We are seeking to purchase the alleyway directly behind our commercial building. Our intention is to build a fence and a gate to make the area safer from drug users and unhoused persons. A secondary intention is to build a dumpster pad in the alley and move our dumpster from the street to the pad to prevent illegal dumping and improve sanitation in the immediate area.

Project Number: PR-2024-009976

4010 Carlisle Blvd. NE between Hilton and Hahn Arroyo Channel – Request for a Vacation of a 25-foot alley.

DRB Project Number: 2024-009976
4010 Carlisle NE

CITY OF ALBUQUERQUE  
BERNALILLO COUNTY  
NEW MEXICO

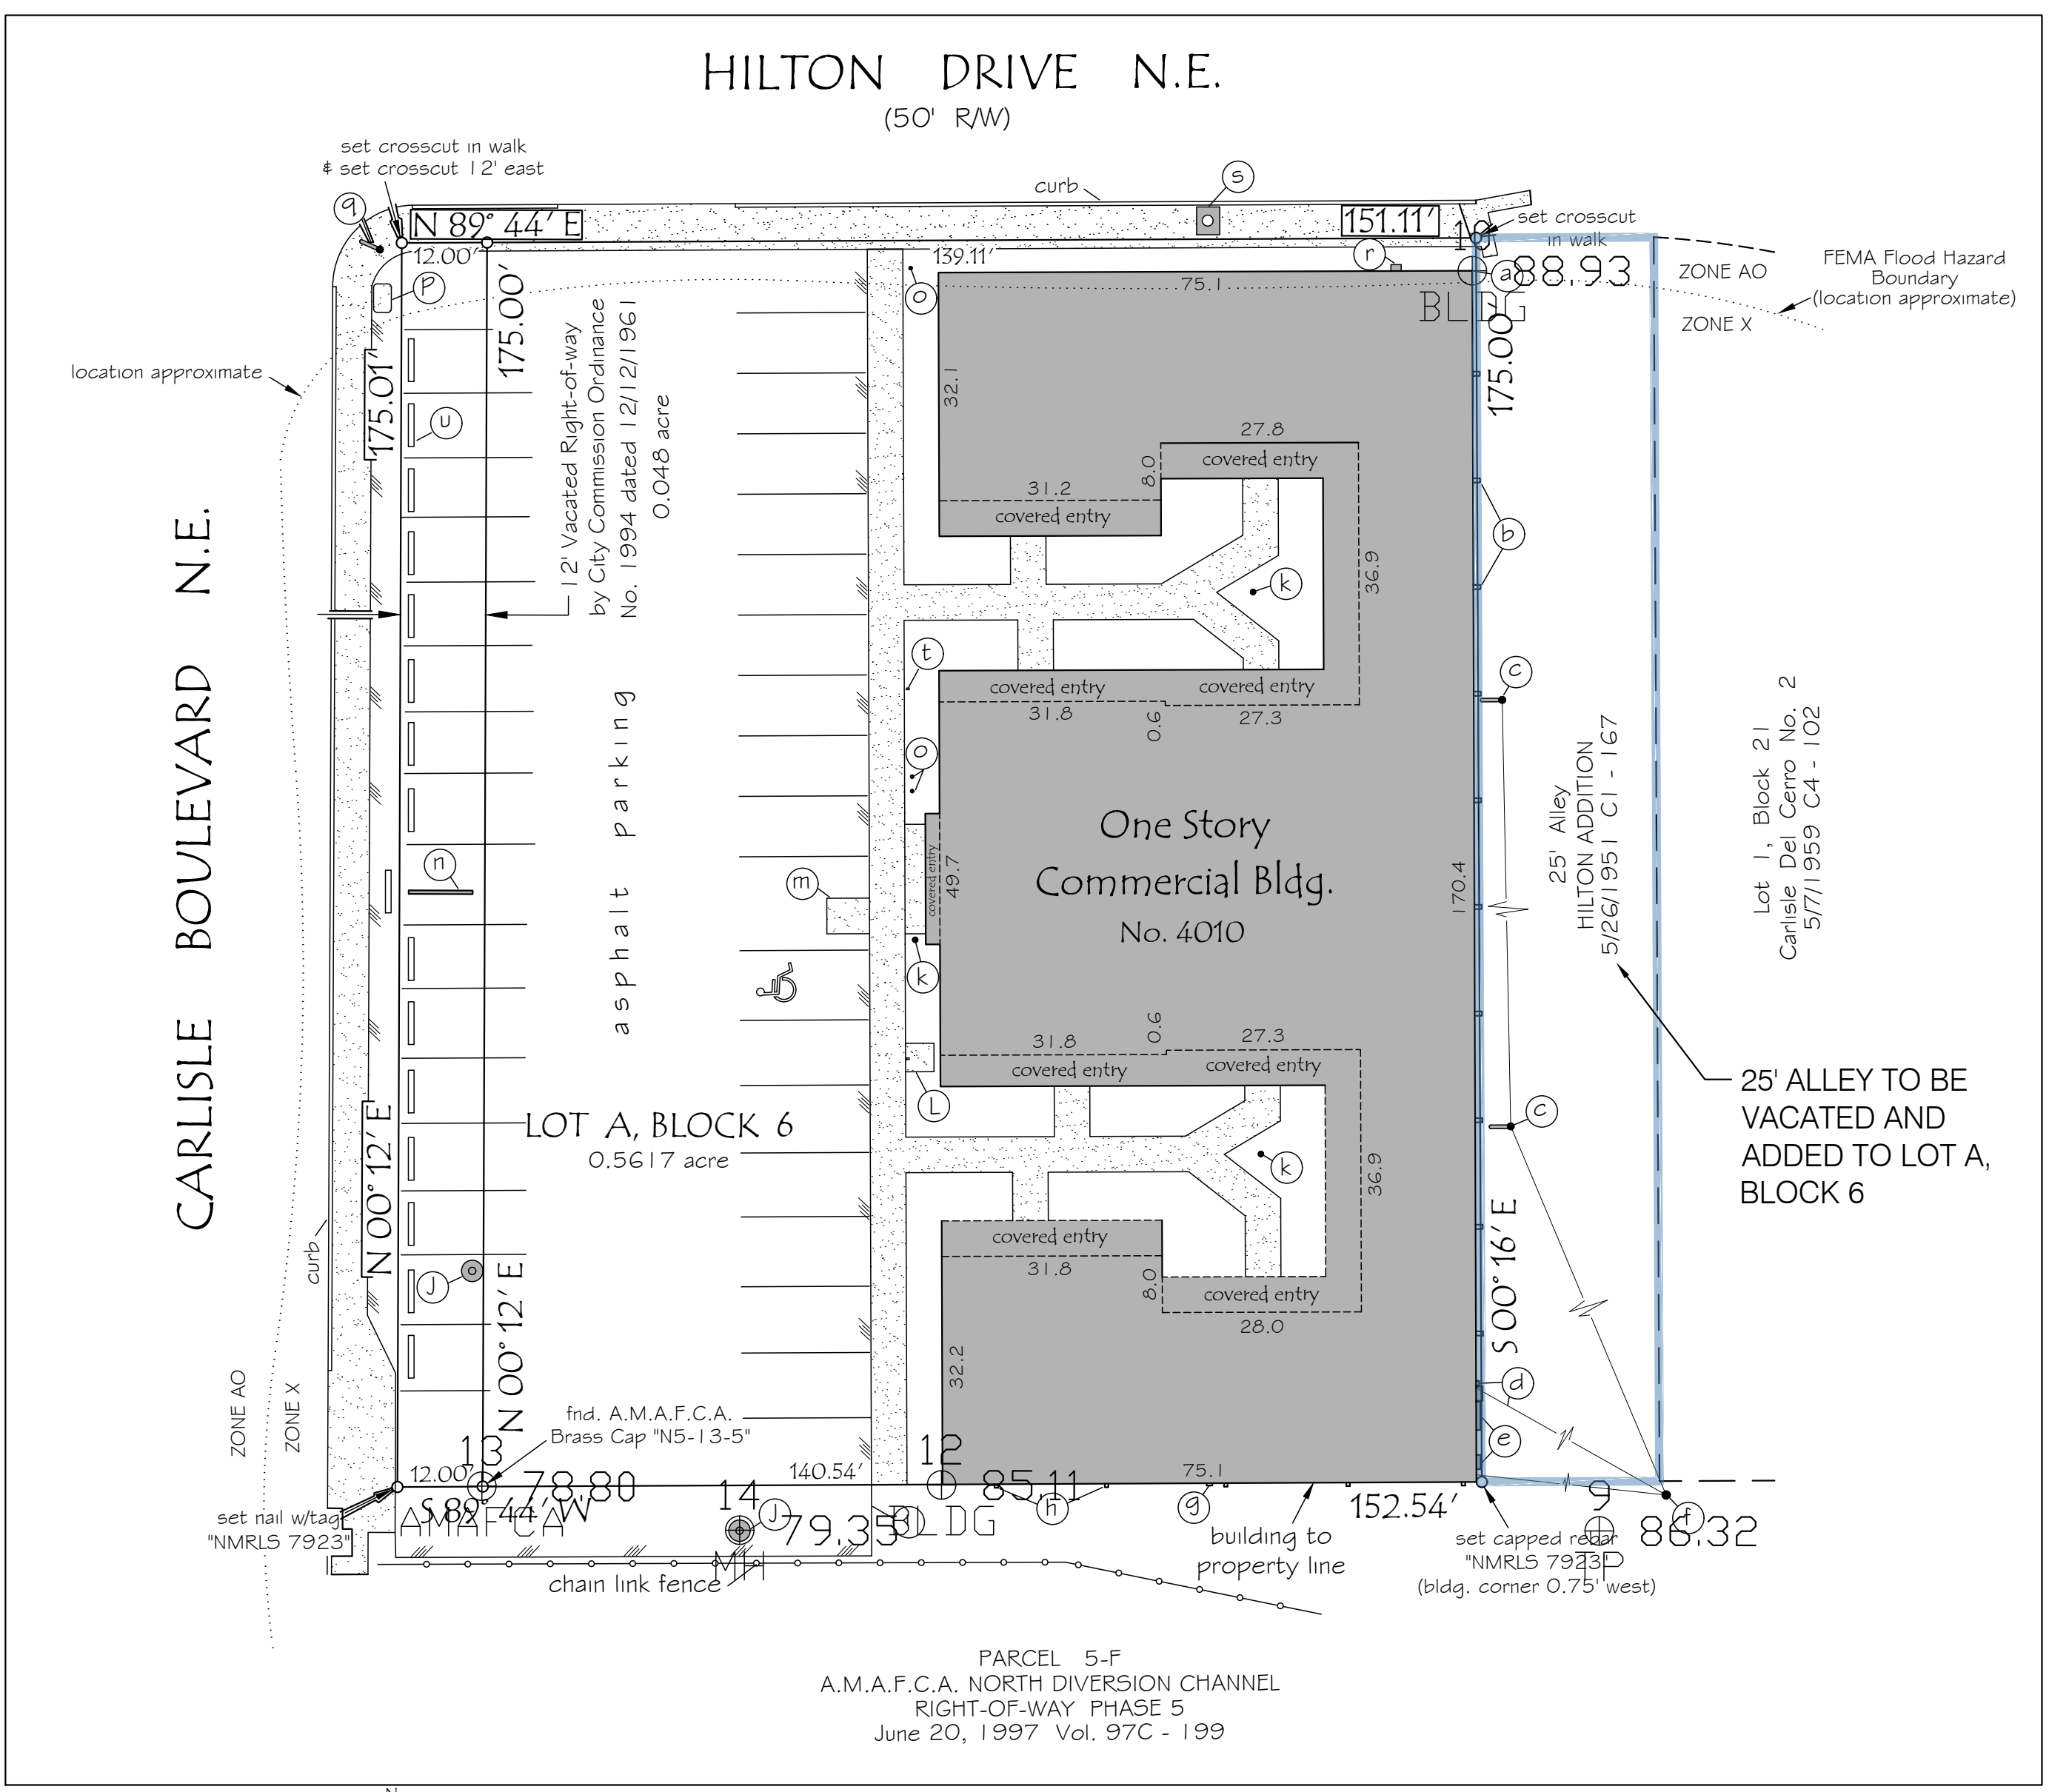
1. Please show width of existing sidewalks and landscape buffers. Carlisle is a Minor Arterial and requires 6' sidewalk with 5' to 6' landscape buffer. Hilton is a local road and requires 5' sidewalk with 4' to 6' landscape buffer. If you are not able to provide the required width you may request a determination with a justification letter.

2. Please list ROW width for Carlisle to ensure it meets City standards in the DPM.
3. It appears that existing property lines along Hilton encroach on the public sidewalk. ROW dedication will be required to ensure sidewalks are completely in City ROW.

4. Transportation has no objection to the vacation, but you will need to check with surrounding property owners as owners adjacent to vacated property have right of first refusal to half of the vacated property. Please work with Real Property on the purchase of vacated property.
